Harnett County
420 Mckinney Pkwy
LILLINGTON, NC 27546
Phone:
Fax:

SUBJECT: BRES2112-0003
BUILDING RESIDENTIAL

Here are the results of all Inspections located at **2835 BARBECUE CHURCH RD:**

(E) FOUNDATION/(N) PIER LAYOUT PLAN

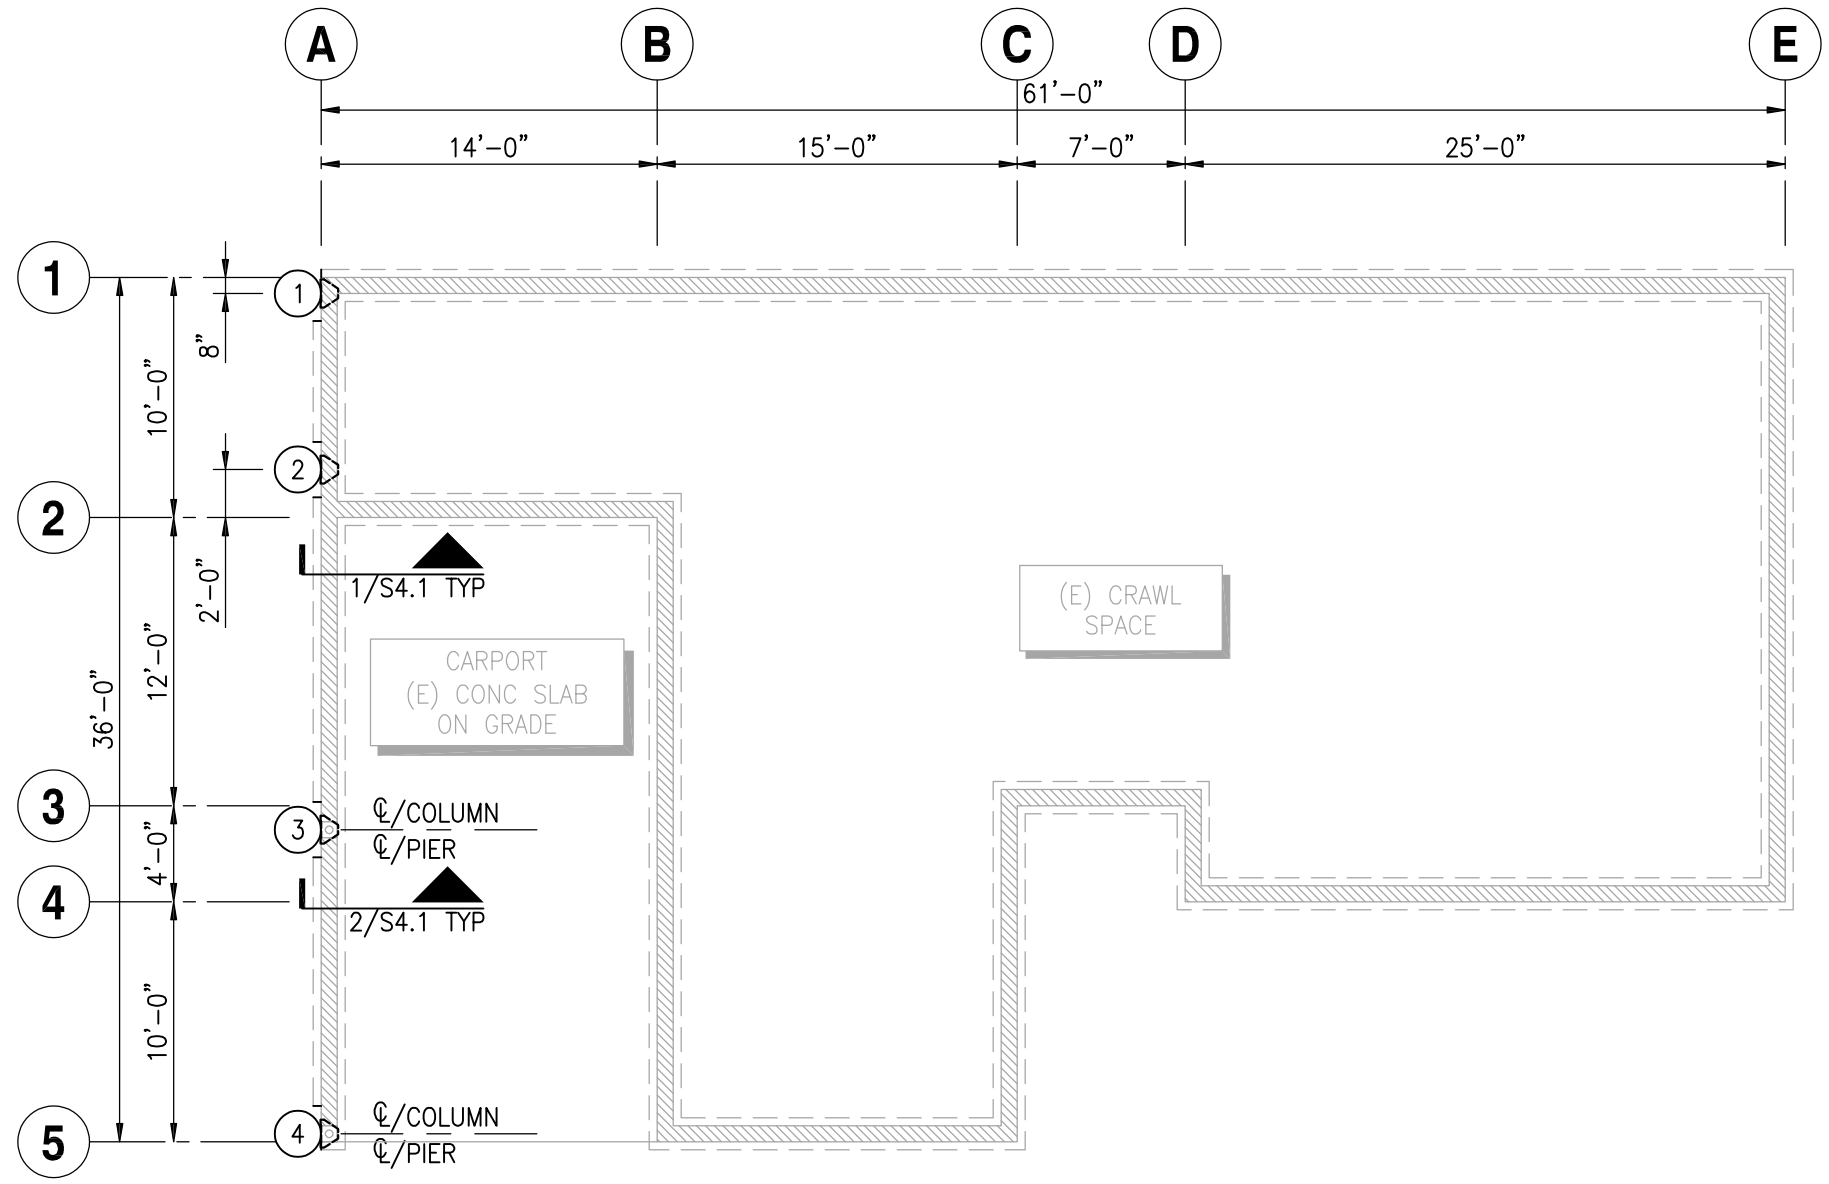
Inspection Type: FINAL**
Scheduled Date/Time: 3/7/2022
Completed Date/Time: 3/7/2022
Inspector: Steven Gazlay
Result: DISAPPROVED
Remarks:
Notes: Piers already backfilled. Piers do not appear to be in the locations specified in drawings.

Inspection Type: FINAL**
Scheduled Date/Time: 10/18/2022
Completed Date/Time: 10/18/2022
Inspector: Steven Gazlay
Result: APPROVED
Remarks:
Notes: Engineer letter attached
